City of Albuquerque Stormwater Construction Site Inspection Report

ESC File No.	A11E011I	Project Name:	McMahon Lots		
NPDES Id. No.	NMR1002NB	Location:	SE corner of McMahon and Unser		
6/1/2021	Owner	Contractor			
Operator	JMD - McMahon	Wilger Construction			
Contact name & title	Doug Peterson	John Wilger			
e-mail	doug@petersonproperties.net	jwilger@wilger.com			
Contact Phone #	505-884-3578				
COA Inspector	Thomas Evans	Start/End Time:			
Construction Phase:	Not active				
Type of Inspection:	<input checked="" type="checkbox"/> Regular	<input type="checkbox"/> Storm Event	<input type="checkbox"/> Past Storm Event >0.25"	<input type="checkbox"/> 311/Complaint	<input type="checkbox"/> Follow Up
Weather at time of inspection?	clear	Temperature:	~	84	
Estimated date of last storm 0.25" or greater	5/31/2021

TEMPORARY EROSION AND SEDIMENT CONTROL PLAN

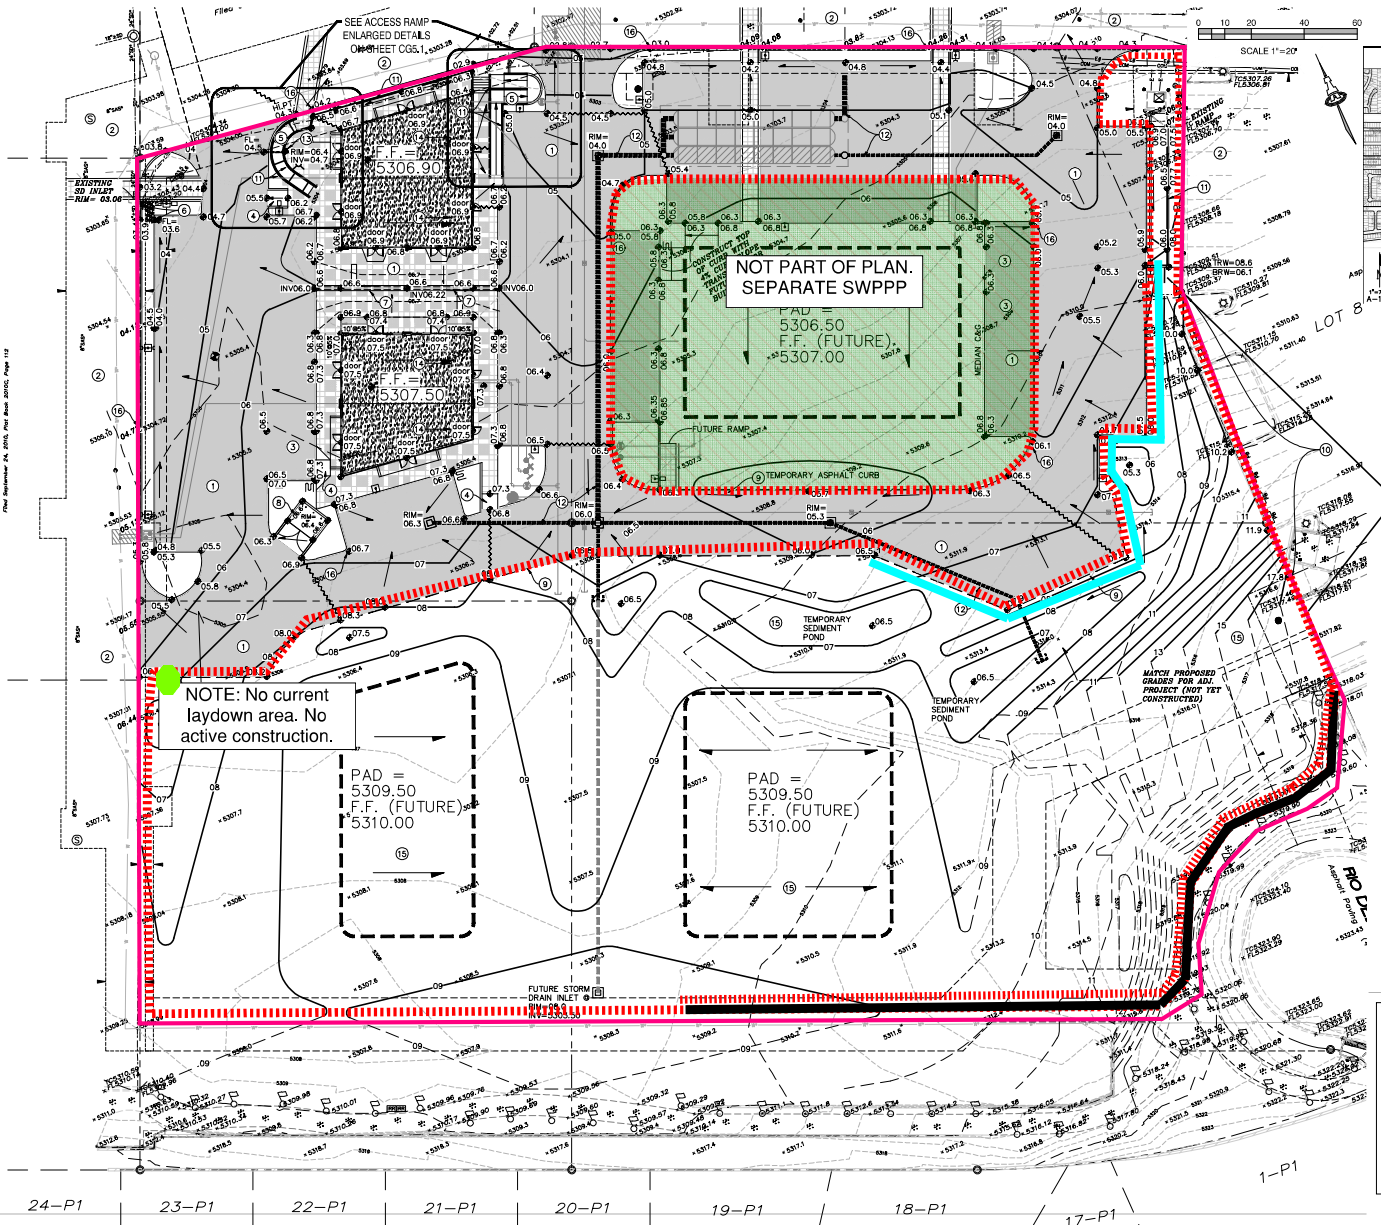
Item Number	Deficiency/ Corrective Action				
1	No posting of NOI permit coverage. Post signage of NOI permit coverage in a location clearly visible to the public.				
2	Sediment accumulated in the parking lot. Remove sediment from the parking lot/street daily.				
3	Silt fence not installed/maintained. Install silt fence around the Northern lot and West border, and repair/replace silt fence that has come down and has holes.				
4	Domestic waste and tumbleweeds accumulated in the SE corner. Remove domestic waste and tumbleweeds and place into an approved waste container.				
5
